CITY OF PORTLAND

February 12, 2002

Re: Waiver Request/ 95 Chadwick St. BP#020079/063 F005

This office has received waiver requests for two code items at the above location:

The following are the elevation and plan you requested for the stairway to the Basement.

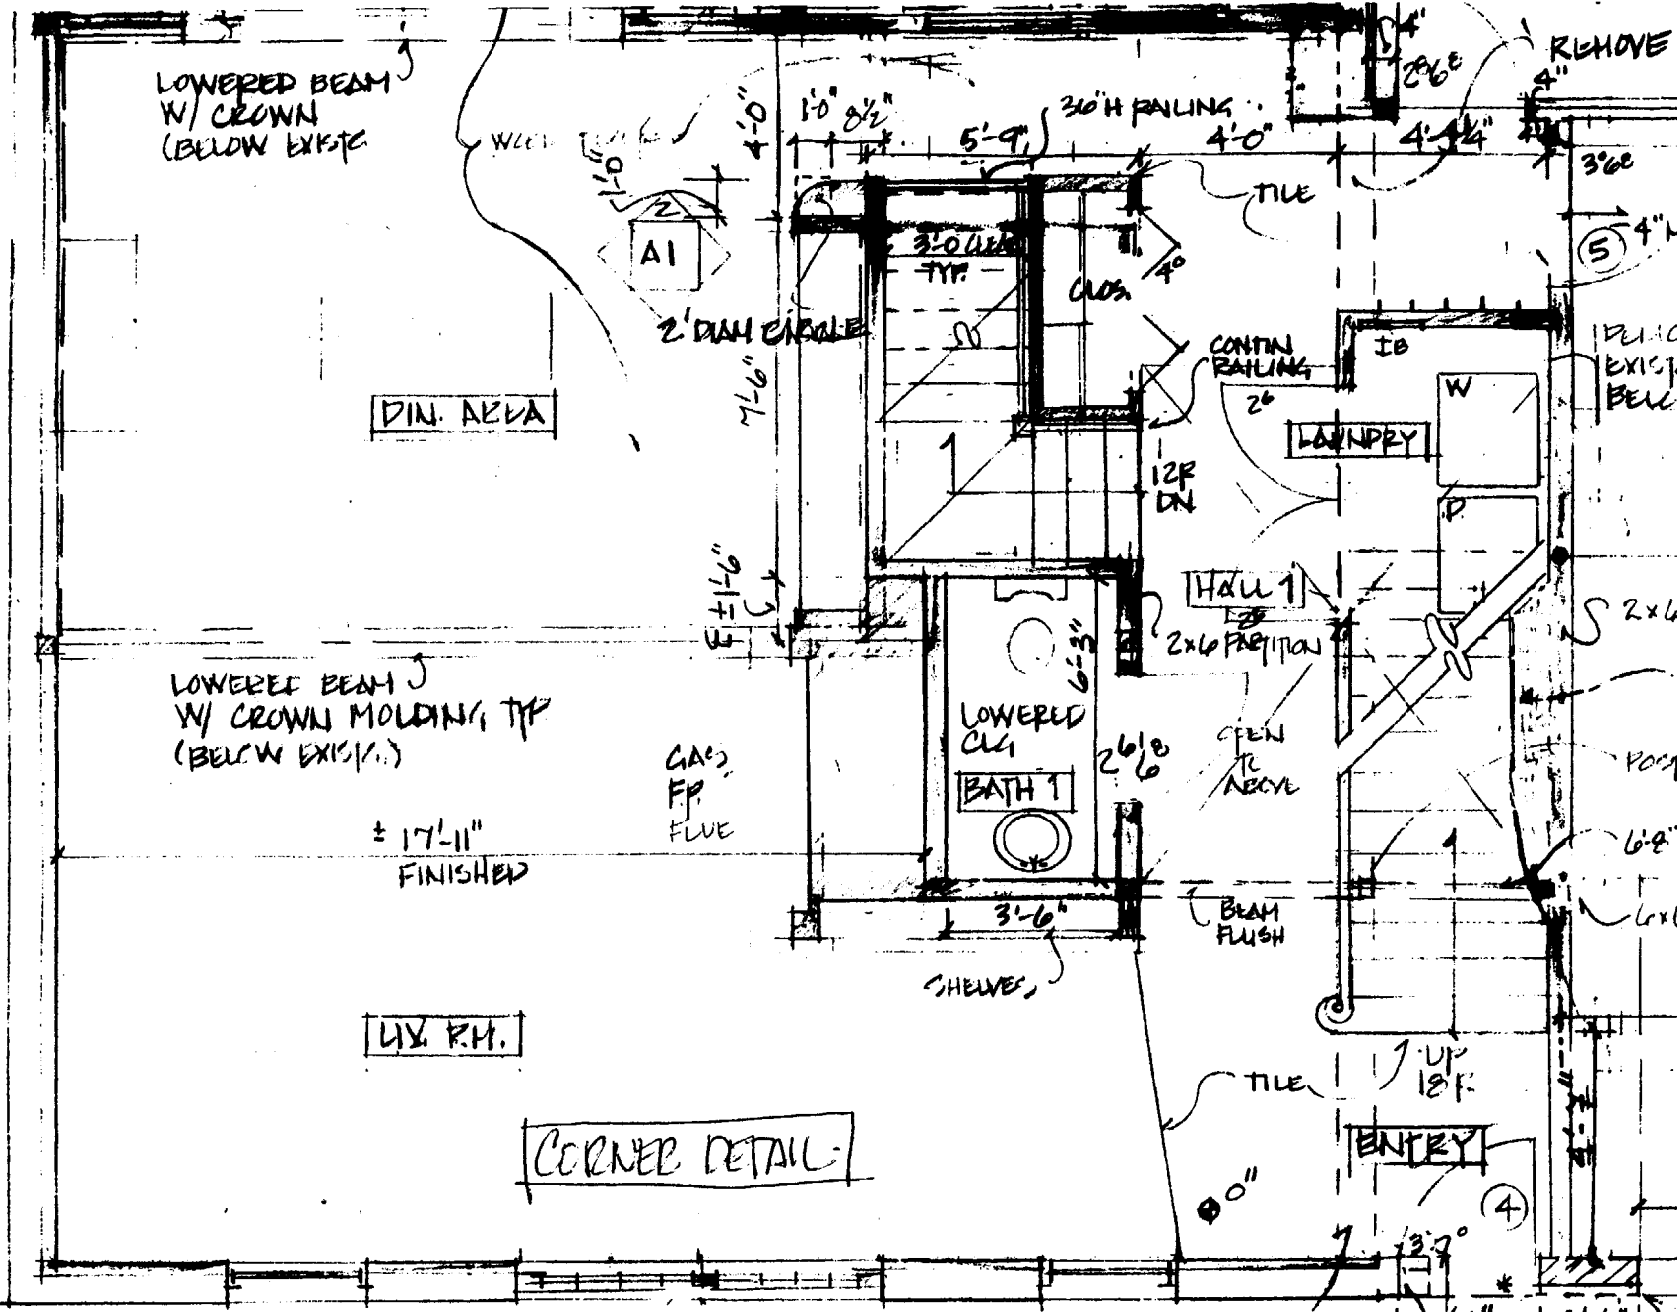
- 1) 5.0 Sq.ft. egress windows in the first floor sleeping room;
- 2) 8.75 net treads on the cellar stairs.

The following are the facts in Item 2:

- a) The project consists of a substantial renovation and conversion to a single family.
- b) The former bulkhead was removed as it encroached on the abutters land and could not be replaced.
- c) The House is in the City's Western Promenade Historic District
- d) The basement is existing with legally nonconforming headroom.
- e) There is not habitable space in the basement.

Based on these facts and pursuant to Sections 121.1 and 3406. of the City Building Code (1999 BOCA w/ local amendment) The proposed stairway (plan attached is approved). All other elements of the project must comply with all other applicable laws and ordinances.
